Sheringham Shoal and Dudgeon Offshore Wind Farm Extension Projects

Draft Statement of Common Ground with National Highways (Revision B)

Deadline 3

Document Reference: 12.22

DRAWING No.	REVISION
PB8164-RHD-ZZ-XX-GA-R-0006	P02

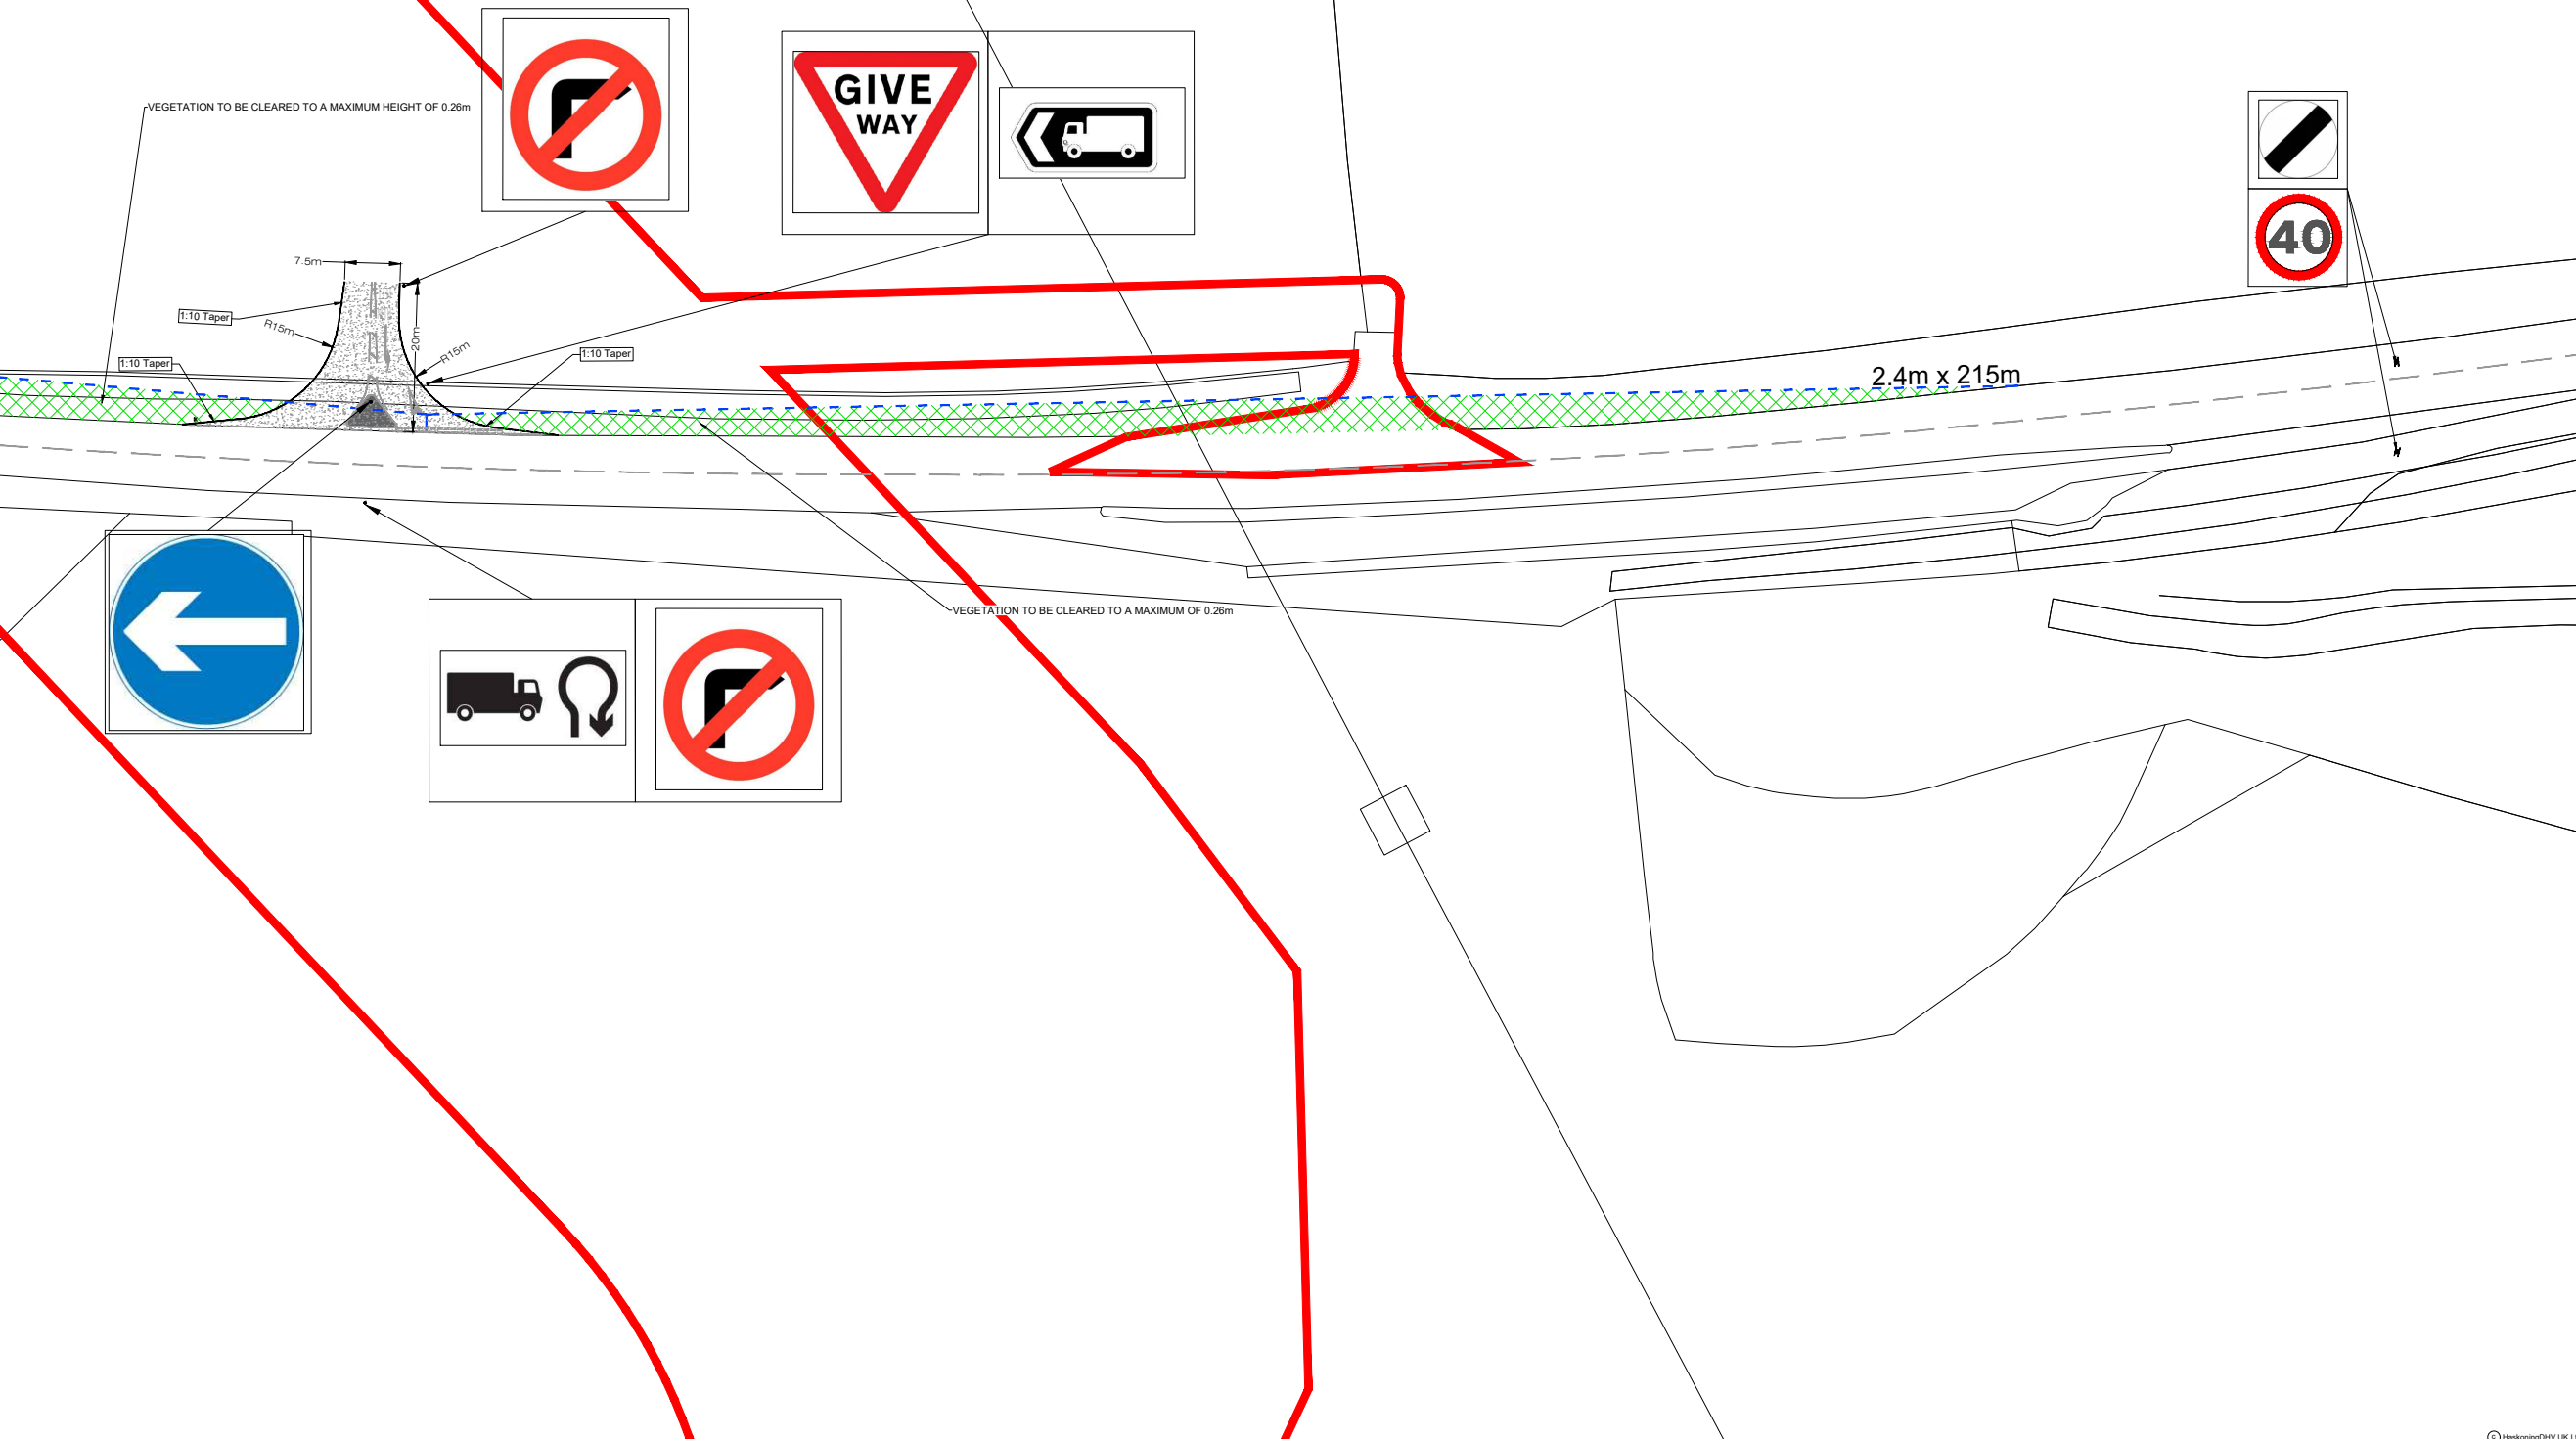
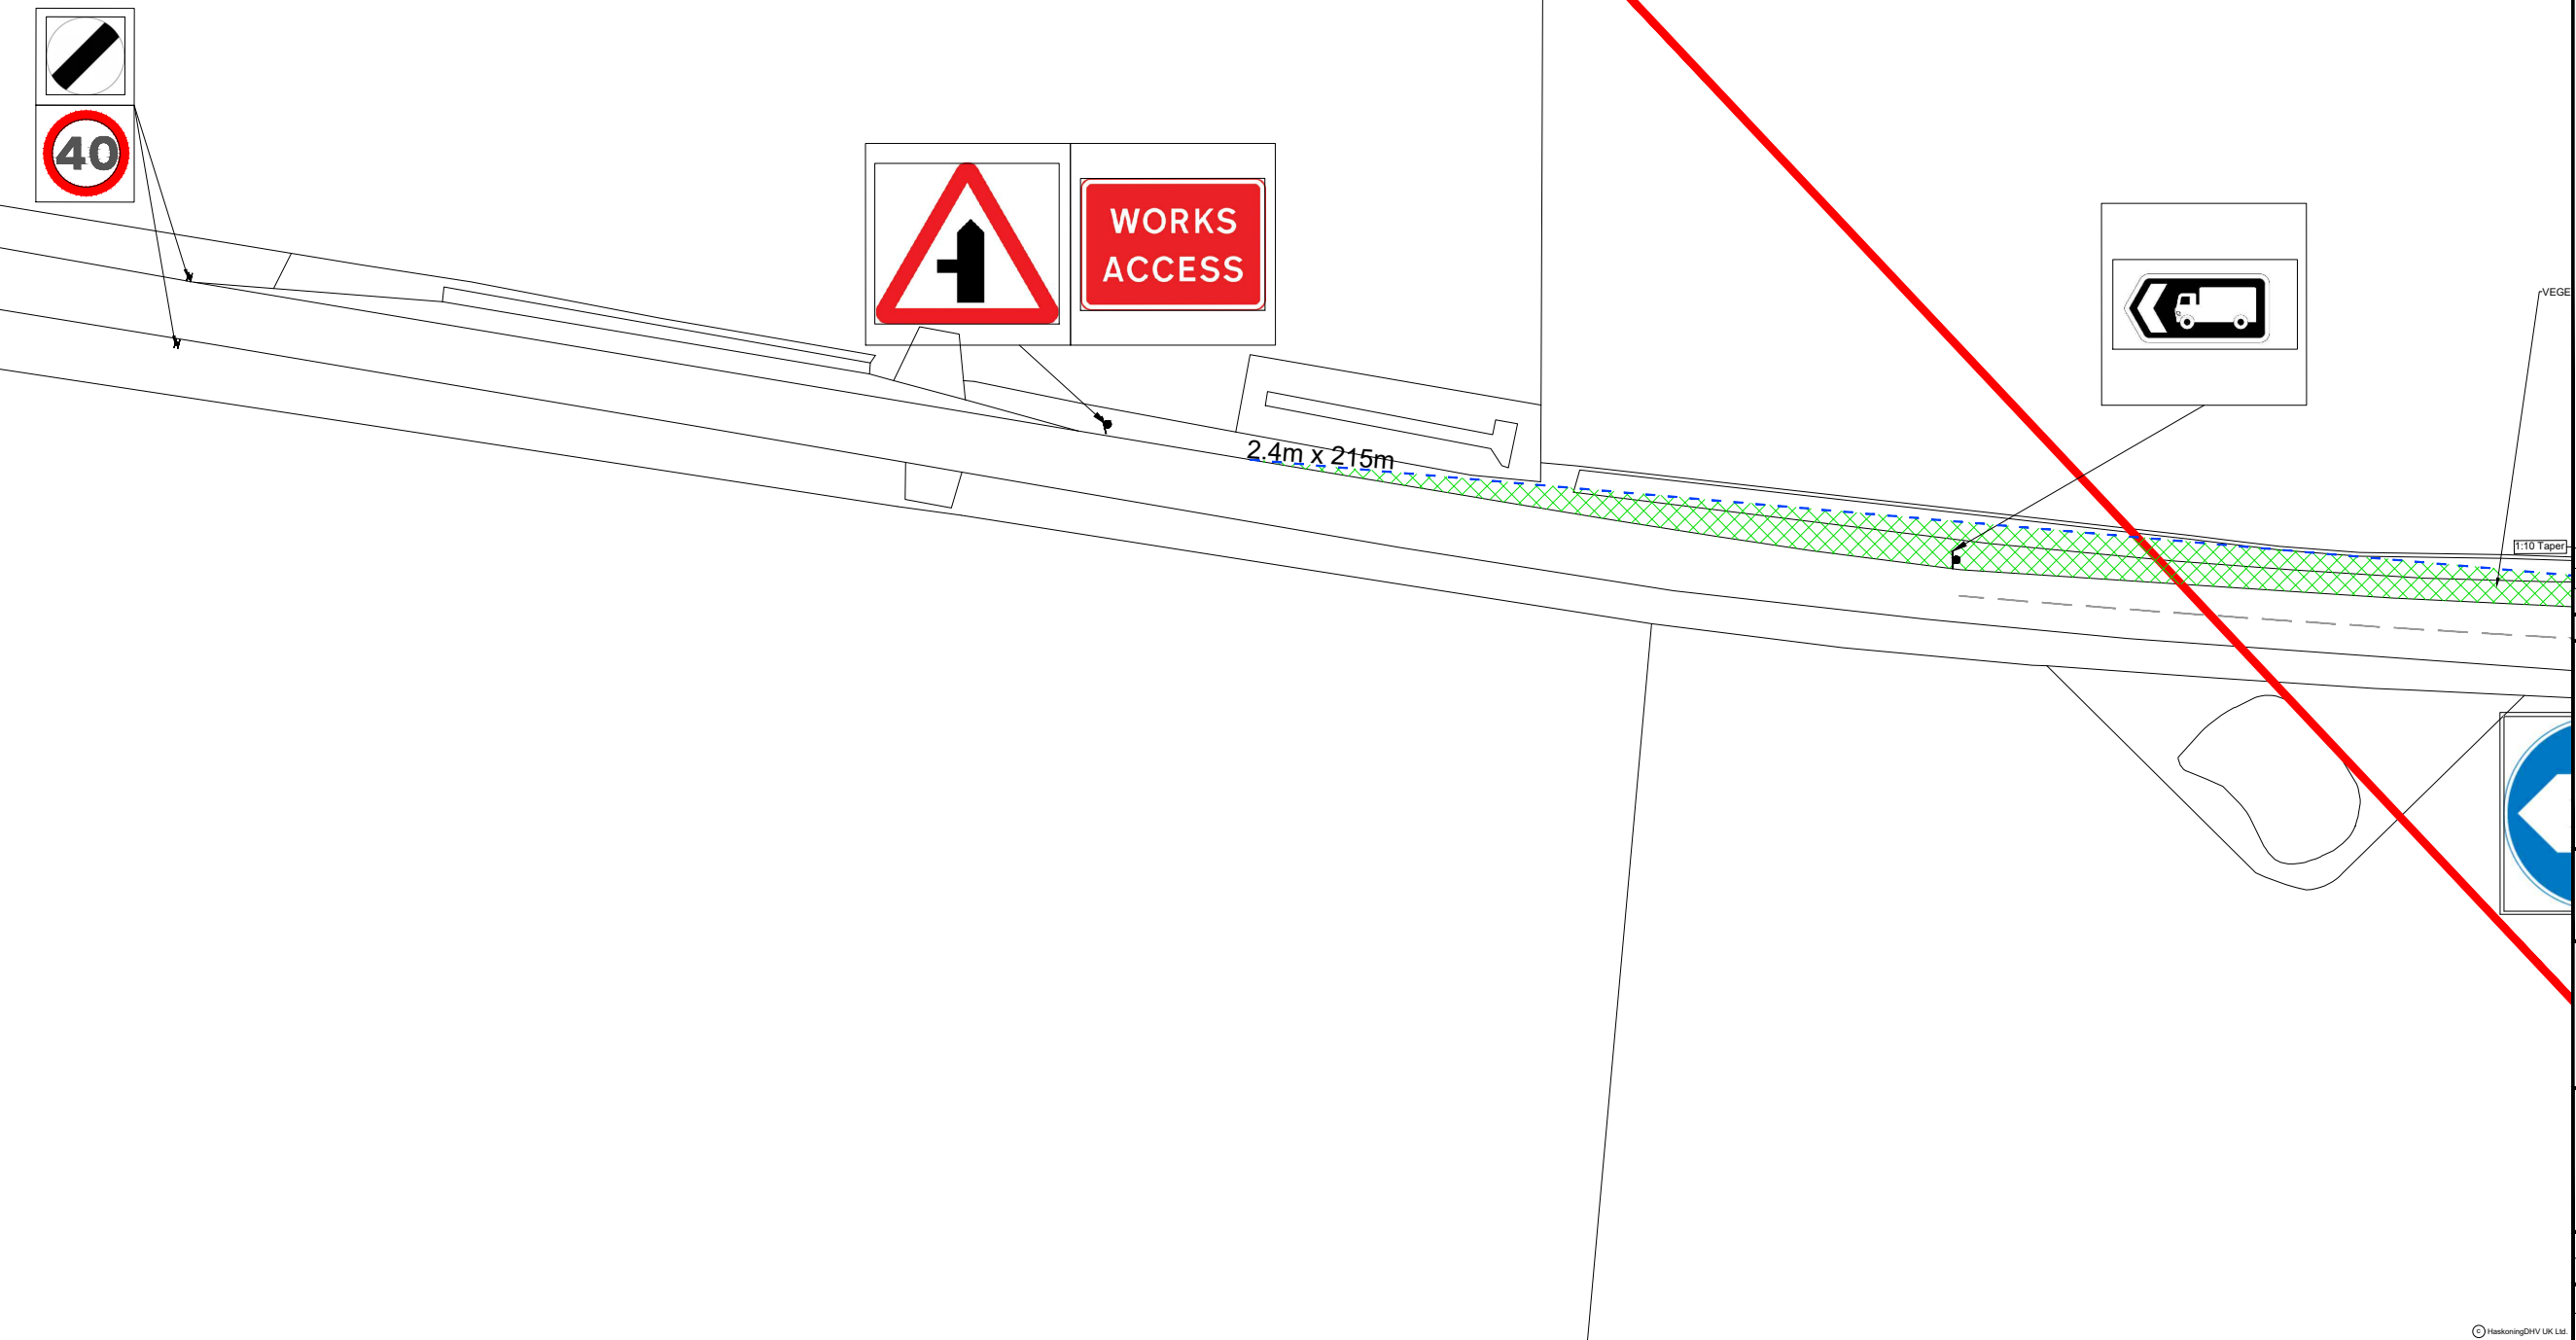
29	The access concept design for access ACC47 is appropriate and that detailed access designs can be developed and agreed with National Highways prior to the start of construction, secured under Requirement 16 of the draft DCO [AS-009].	<i>National Highways agree that the access concept design for access ACC47 is appropriate, subject to a Stage 1 Road Safety Audit to be carried out post consent, and that detailed designs can be developed and agreed with National Highways prior to the start of construction, secured under Requirement 16 of the draft DCO.</i>	Agreed
30	The monitoring procedures set out in the OCTMP [APP-301] are appropriate.	<p><i>The Applicant and National Highways' have agreed that minor amendments are required to the wording in regard to provision of monitoring reports. National Highways' position is therefore reserved pending further review of the amendments to the OCTMP at Deadline 3.</i></p> <p><i>National Highways have requested further amendments to the OCTMP (28/04/2023). The requested amendments would include a monitoring group that is set up and chaired by the Applicant which will consider whether the CTMP is being carried out and working. The monitoring group will include</i></p>	In Discussion
